Our Ref: SSD 8859

**Response to Submissions
1111-1116 Elizabeth Drive, Cecil Park subdivision (SSD 8859)**

ATTACHMENT 1 – DEPARTMENT OF PLANNING AND ENVIRONMENT ISSUES

DRAWING TITLE
EARTHWORKS CUT-FILL PLAN

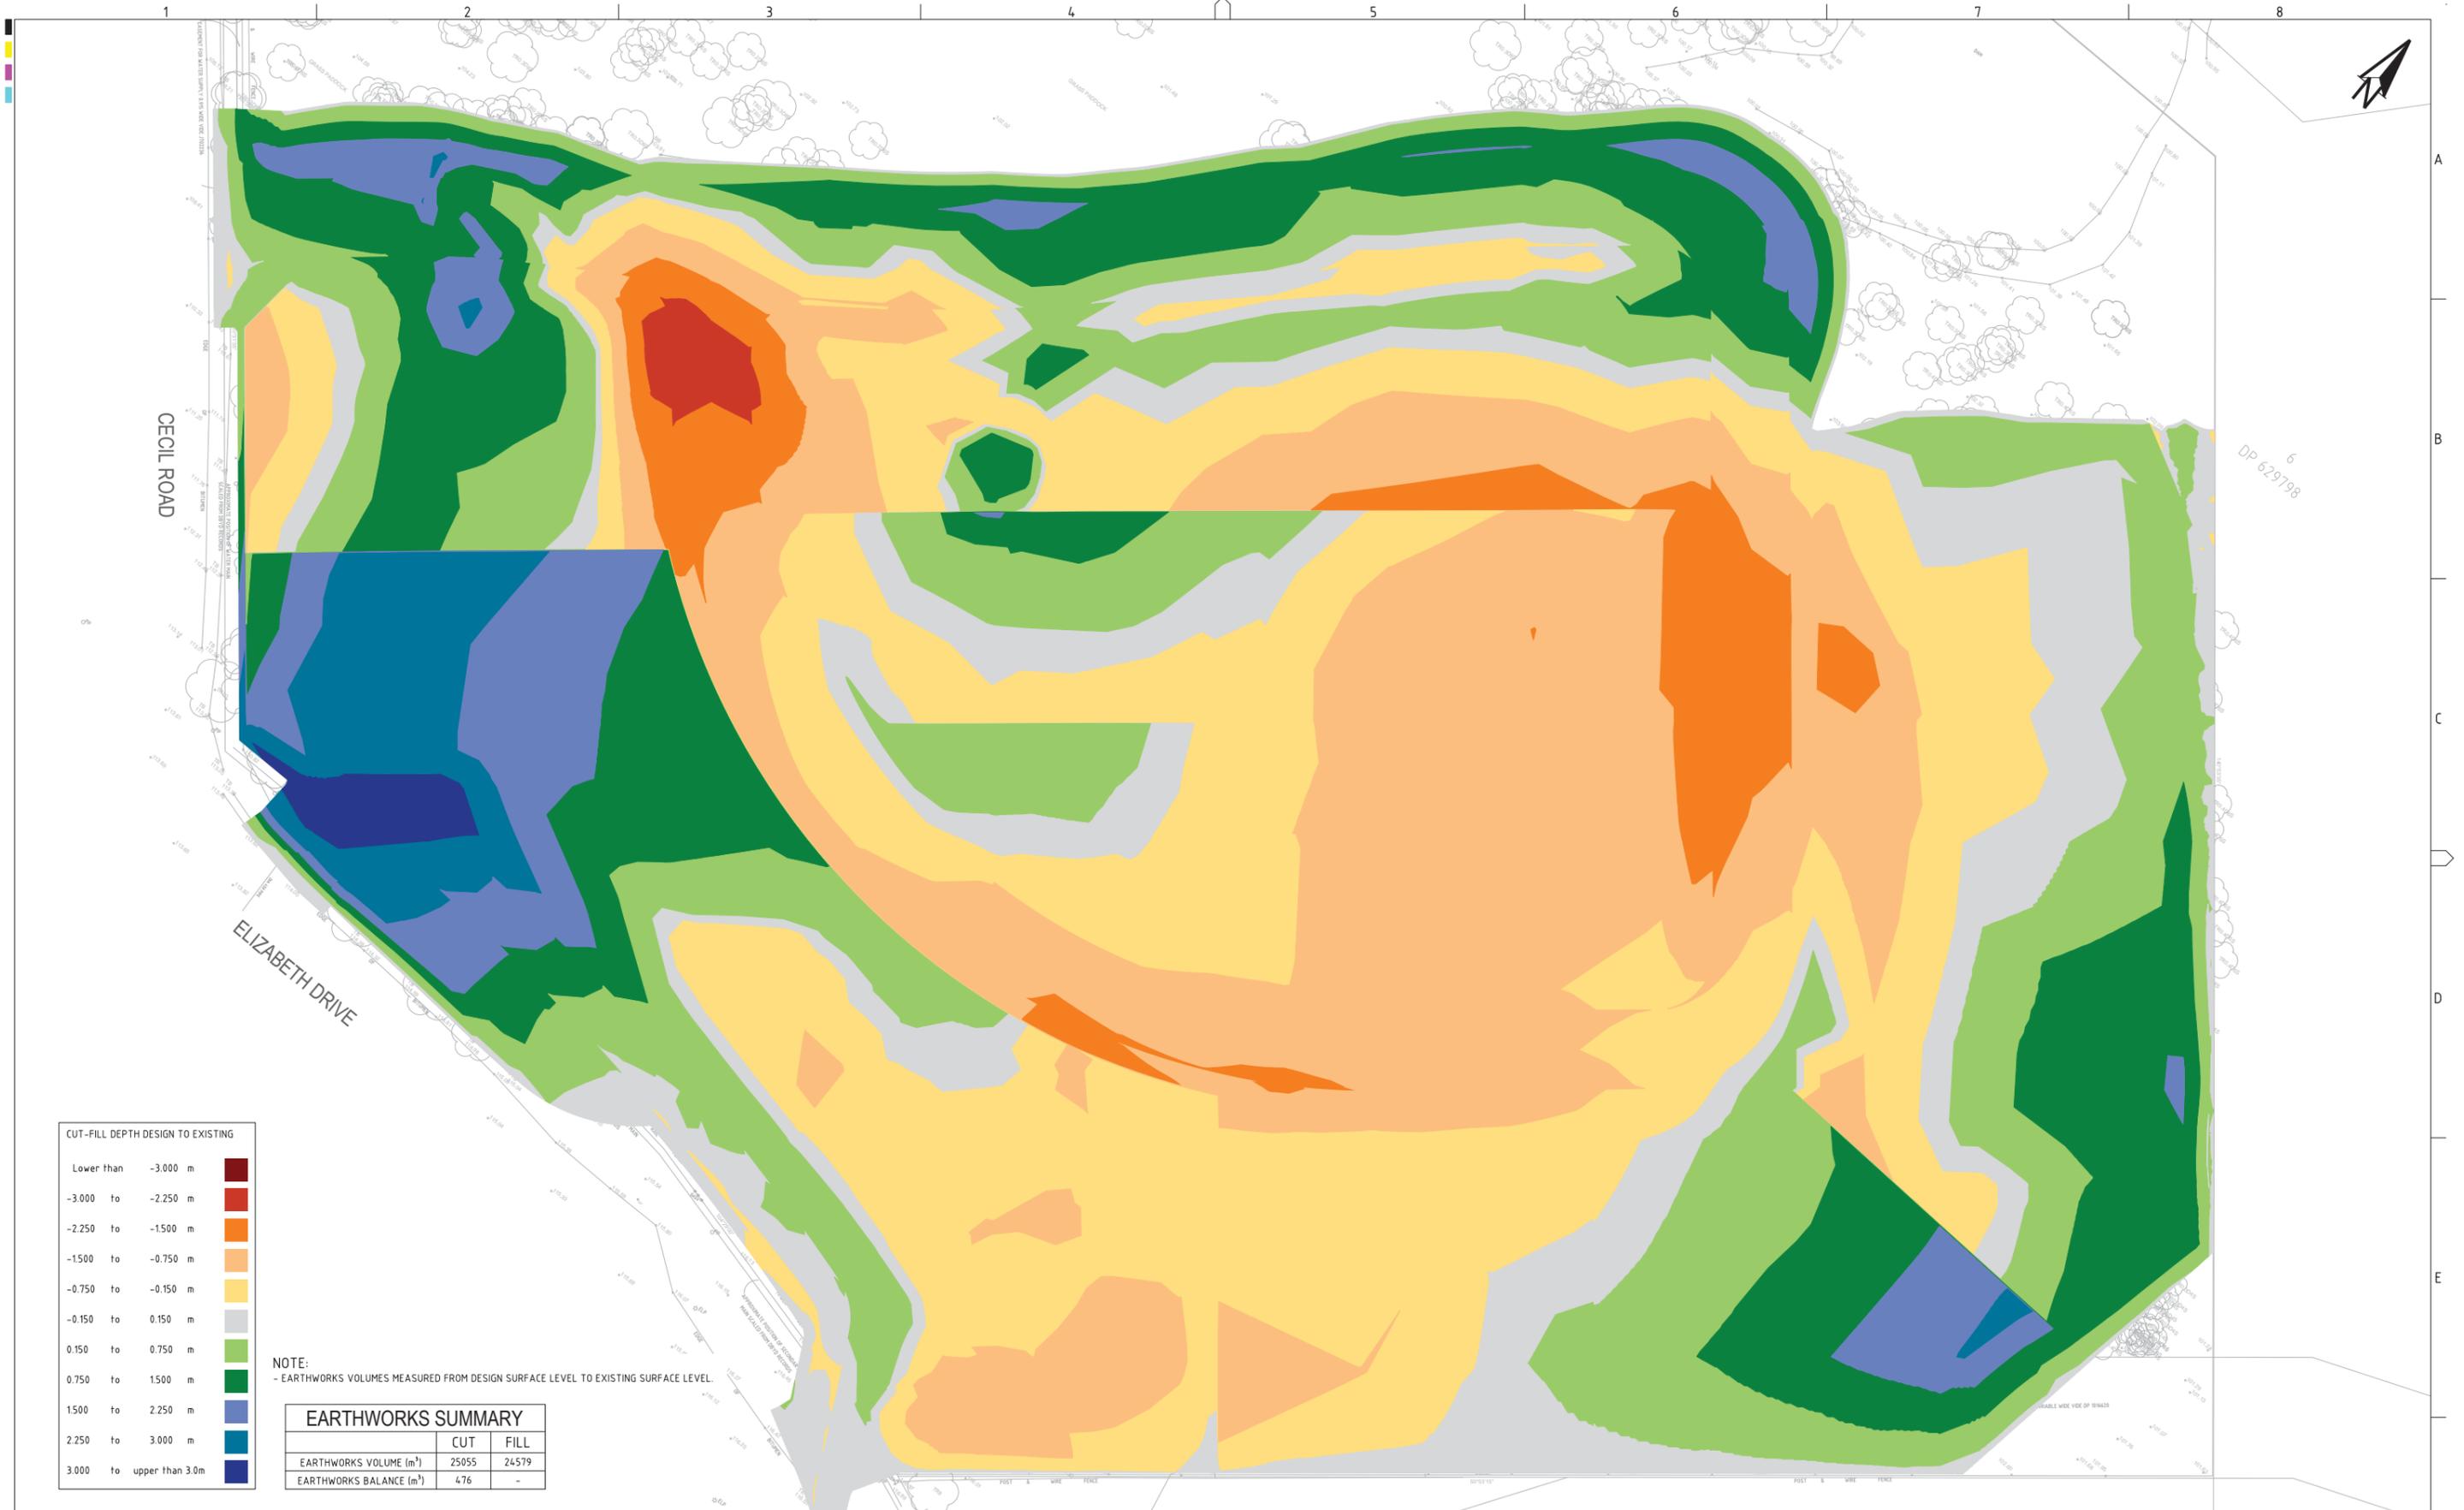
24. Provide a detailed retaining wall plan which shows:
 - a) heights of all proposed retaining walls
 - b) sectional plans
 - c) retaining wall design.
25. Provide a detailed plan showing all cut and fill proposed on site.
